## TREES & CONSTRUCTION MEMO

To: Matt Glaser, McCullough Architects  
From: Bob Layton  
CC: Bogdan Maksimchuk, Barcelo Homes  
Date: April 12, 2022  
Re: Tree Protection at 7216 93<sup>rd</sup> Ave SE – Tree #18

TREE RETENTION PLAN
LOT 1 - SFR (93RD AVE SE)
PREMIUM HOMES OF MERCER ISLAND LLC
PO BOX 1639 98040
MERCER ISLAND, WA 98040
(206) 724-1072

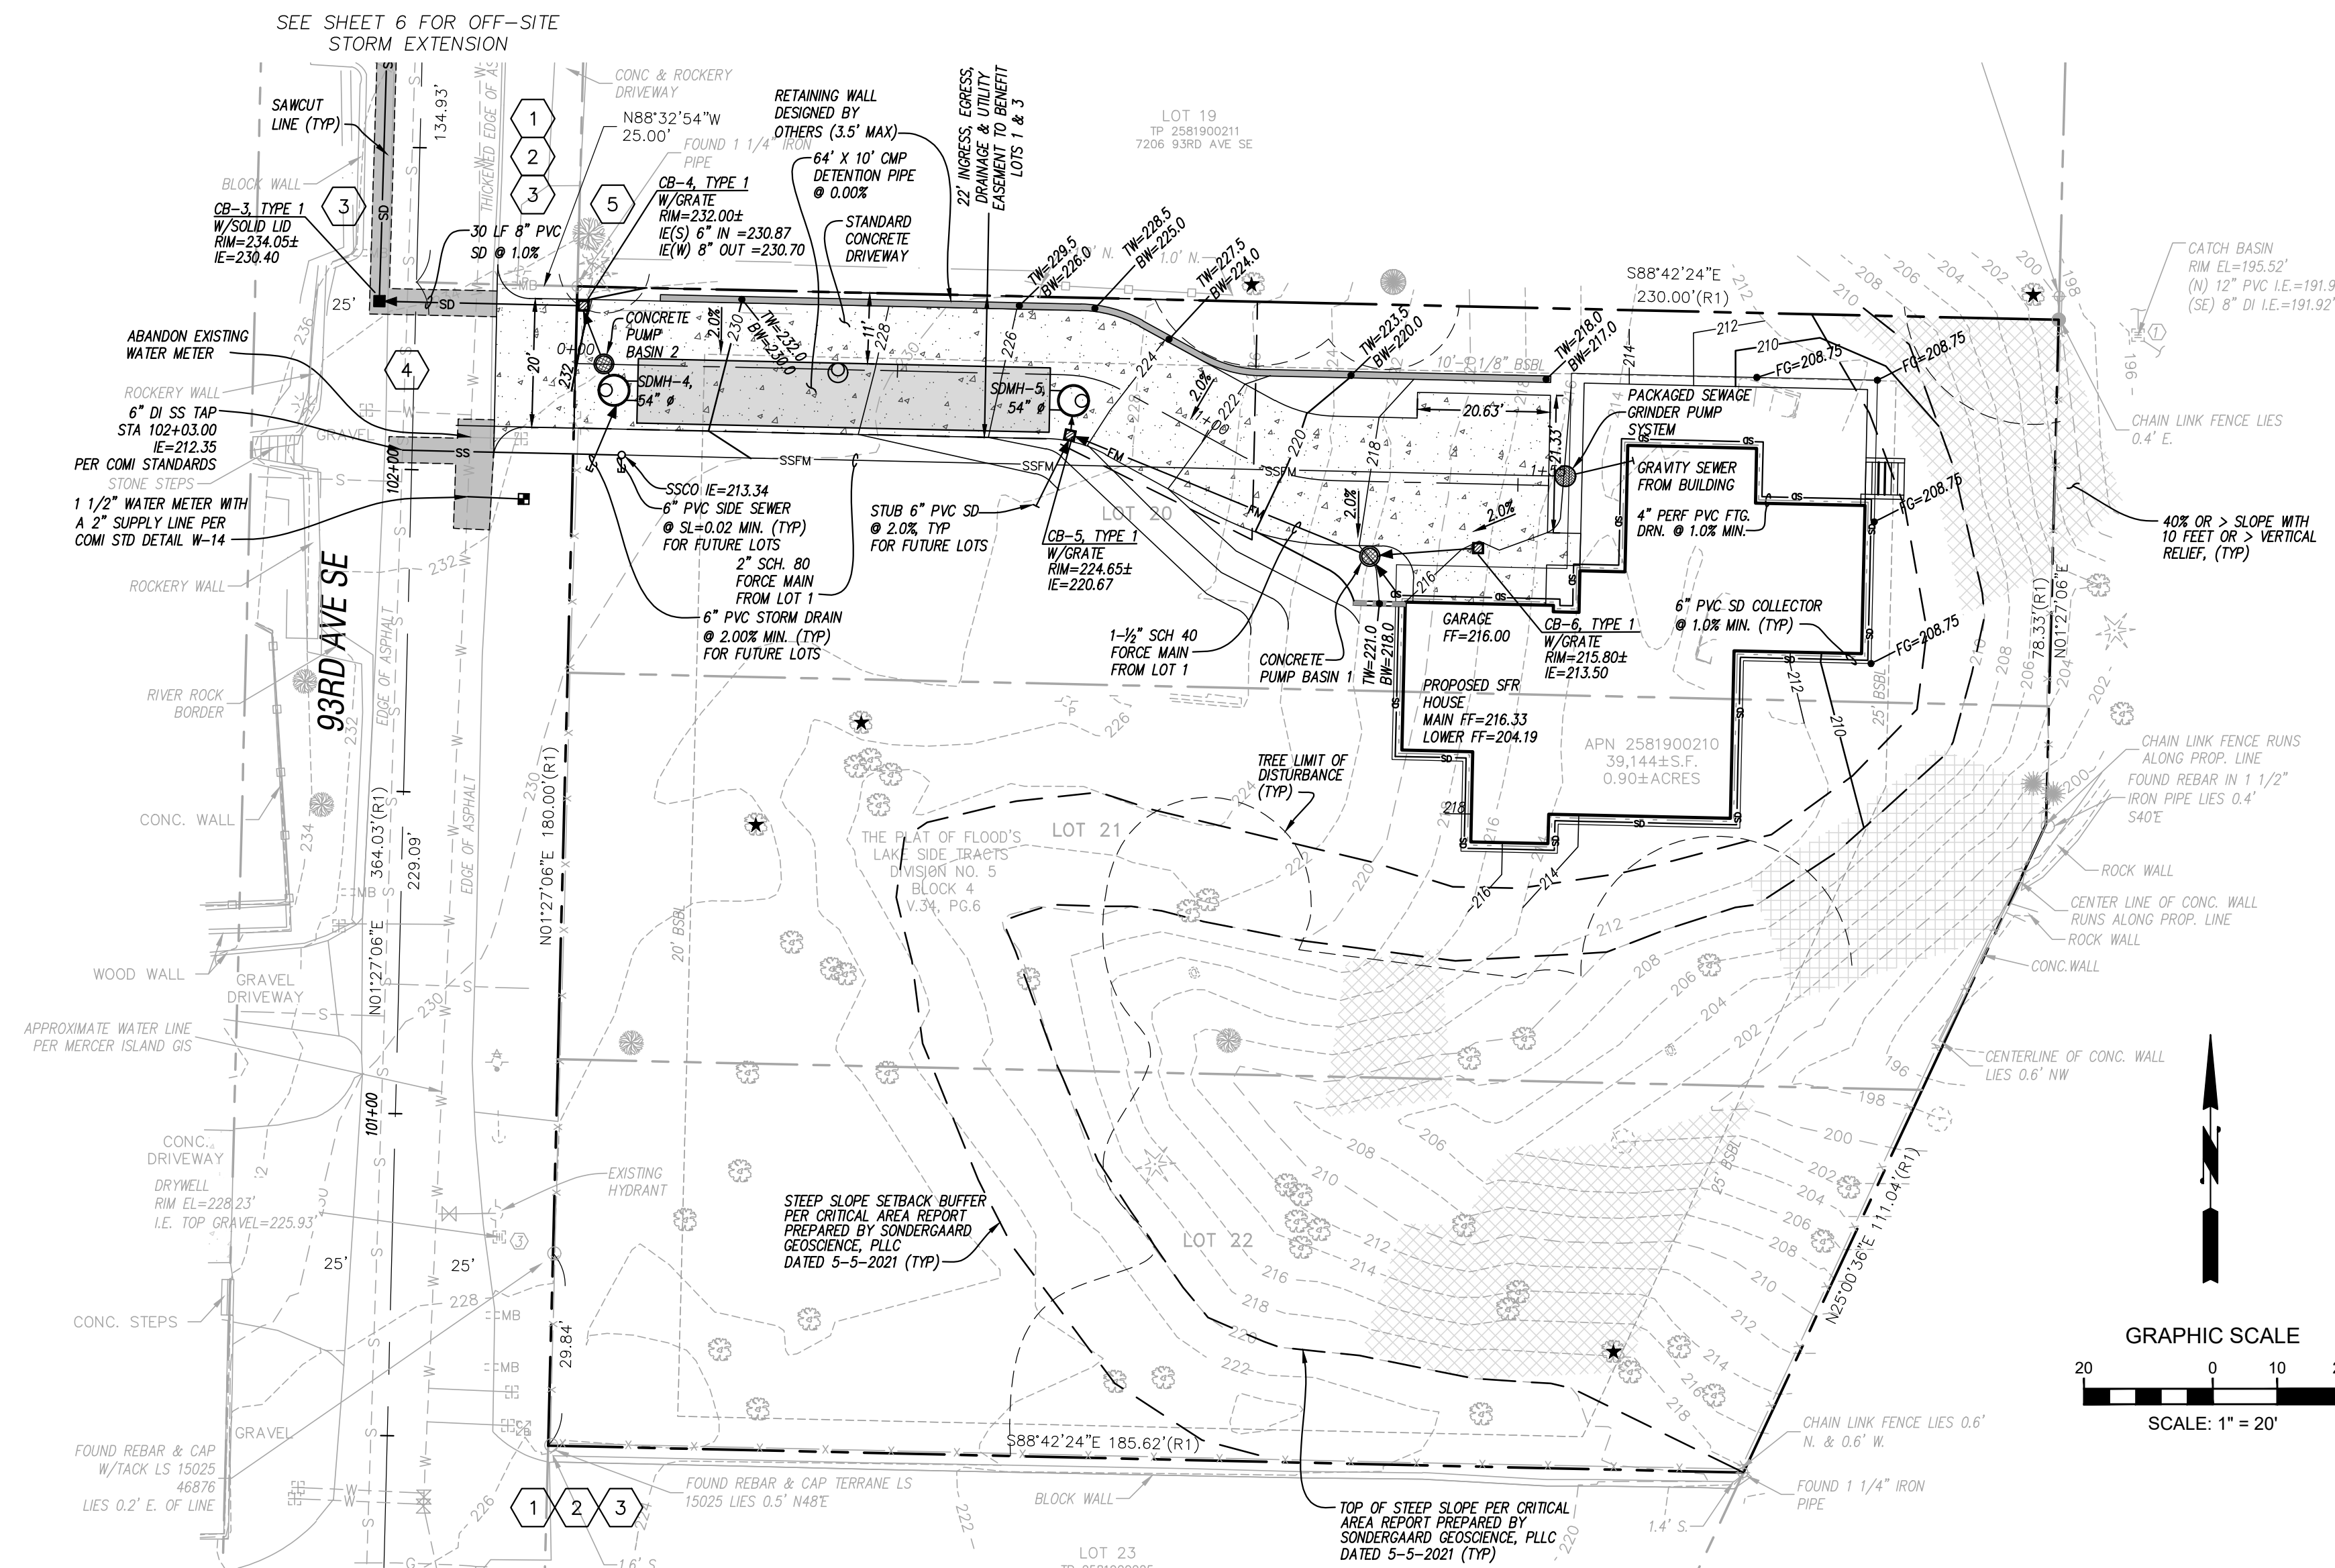
The tree protection fencing shown on the initial site plan did not allow appropriate access for new construction. The city wants a minimum of 5-feet of clearance between the tree protection barrier and the new house. Apparently, the cut for the basement/foundation will be deep and require an eco-block wall to support grade during the excavation.

On Friday, a 2-foot-deep trench was air-excavated at 8-feet south of the trunk face of Tree #18 so the presence and size of existing roots could be inspected and ascertained. Eight roots greater than 2-inches in diameter were exposed. The largest root is 4-inches in diameter. There were also 3 – 3-inch diameter roots and 4 - 2-inch. See pictures below. There also a few large roots from the mature English laurel shrubs that cover the area.

Cutting the roots at this location is not recommended. Long-term tree health is likely to be jeopardized. I would be comfortable allowing an 11-foot Limit of Disturbance from the trunk face as shown on the attached diagram. The roots at this distance would be notably smaller than those exposed at 8-feet from the trunk face. I would not expect any consequential impacts on the long-term health or stability of the tree so long as work is carried out diligently and the tree protection recommendations and guidelines as outlined in the arborist report and below are adhered to. This would also afford 6-feet of clearance between the tree protection zone and the new building at the closest distance to the tree.

Bigleaf maple is a hardy species and tolerable of the proposed impacts, so long as work is carried out diligently. Protecting the soils within areas that do not need to be disturbed will be important to reduce the overall impacts and stress on the tree. Cover all of these areas with a protective covering of a +/- 6-inch layer of coarse wood chip mulch or hog fuel.

All severed or damaged roots at the excavation limits outside of tree protection areas will be hand-excavated and pruned back to healthy, sound tissue, prior to backfilling or finishing areas. Sound tissue is where the root is undamaged and the bark is completely intact with the root.
